Subject: BR/244/20/PL- The Beach Hotel, former Mud Club & 2-4 Waterloo Square Bognor Regis PO21 1SU

Engineers Comments Regarding Surface Water Drainage

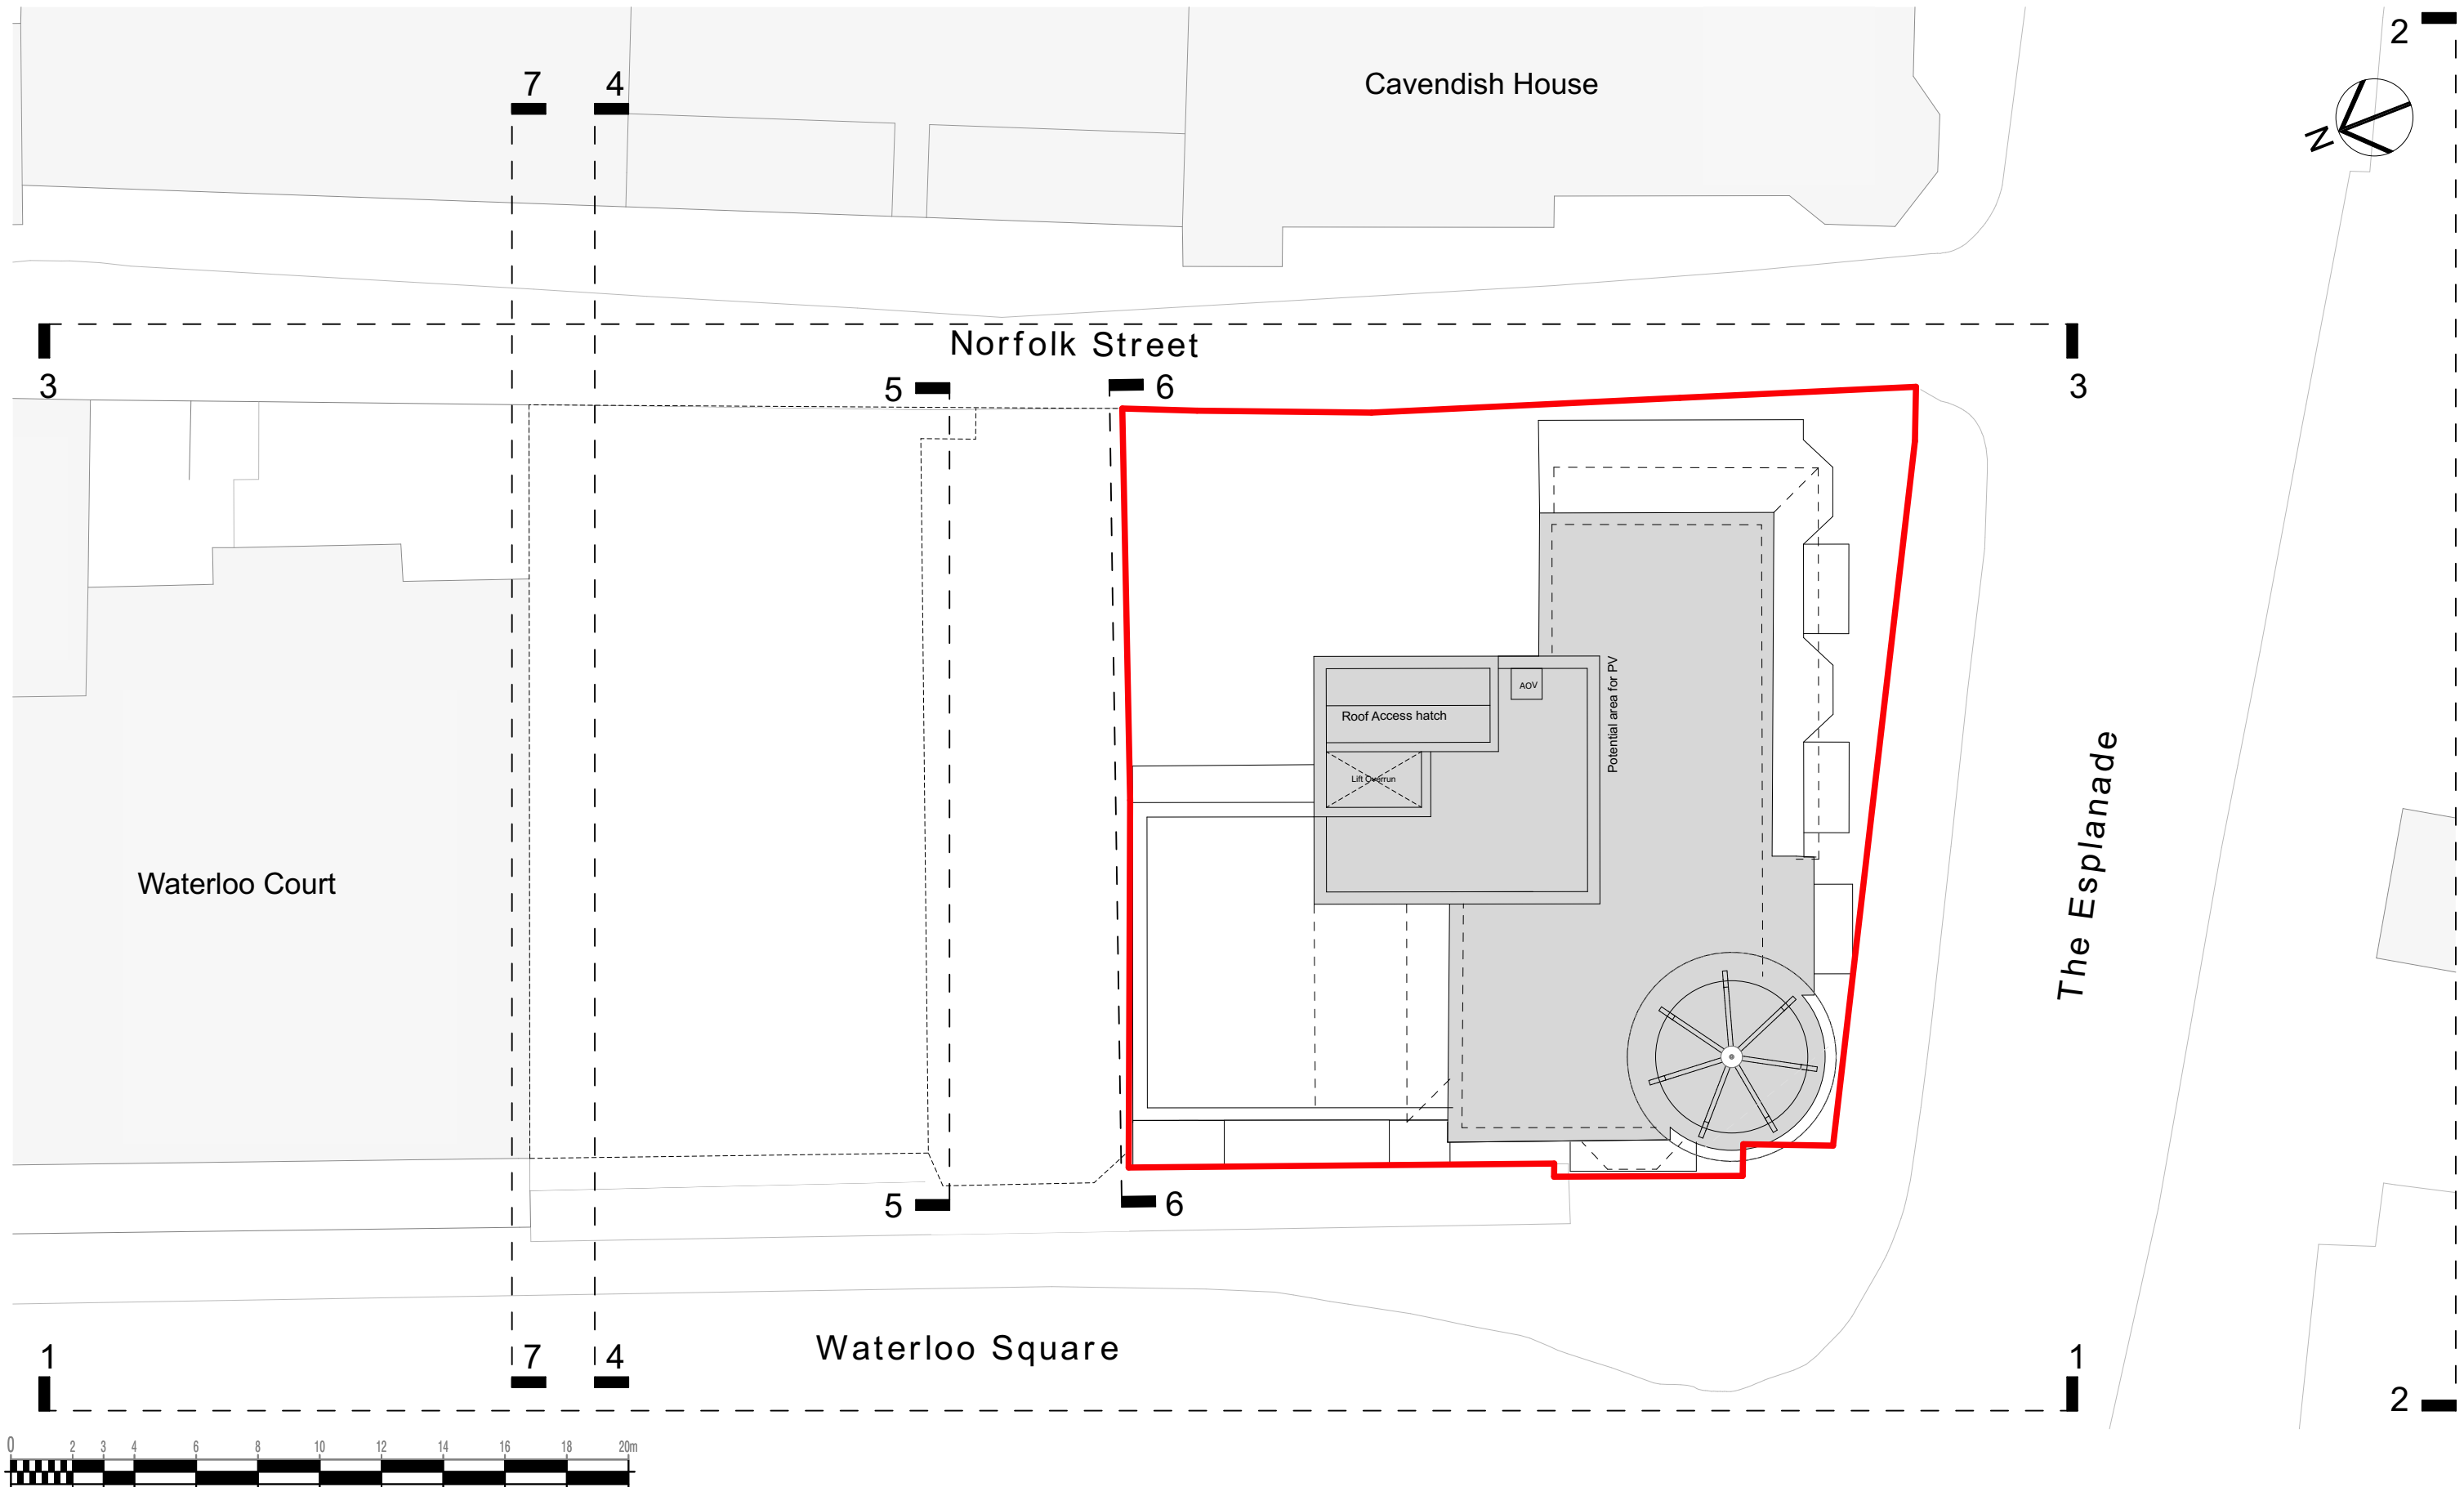
The FRA submitted includes proposals for a green roof and tank storage to be provided to limit discharge to the surface water sewer. We support such proposals on a site of this nature where available space is limited. The proposals follow the hierarchy for sustainable drainage.

"Development shall not commence, other than works of site survey and investigation, until full details of the proposed surface water drainage scheme have been submitted to and approved in writing by the Local Planning Authority. The design should follow the hierarchy of preference for different types of surface water drainage disposal systems as set out in Approved Document H of the Building Regulations, and the recommendations of the SuDS Manual produced by CIRIA. No building / No part of the extended building shall be occupied until the complete surface water drainage system serving the property has been implemented in accordance with the agreed details and the details so agreed shall be maintained in good working order in perpetuity."
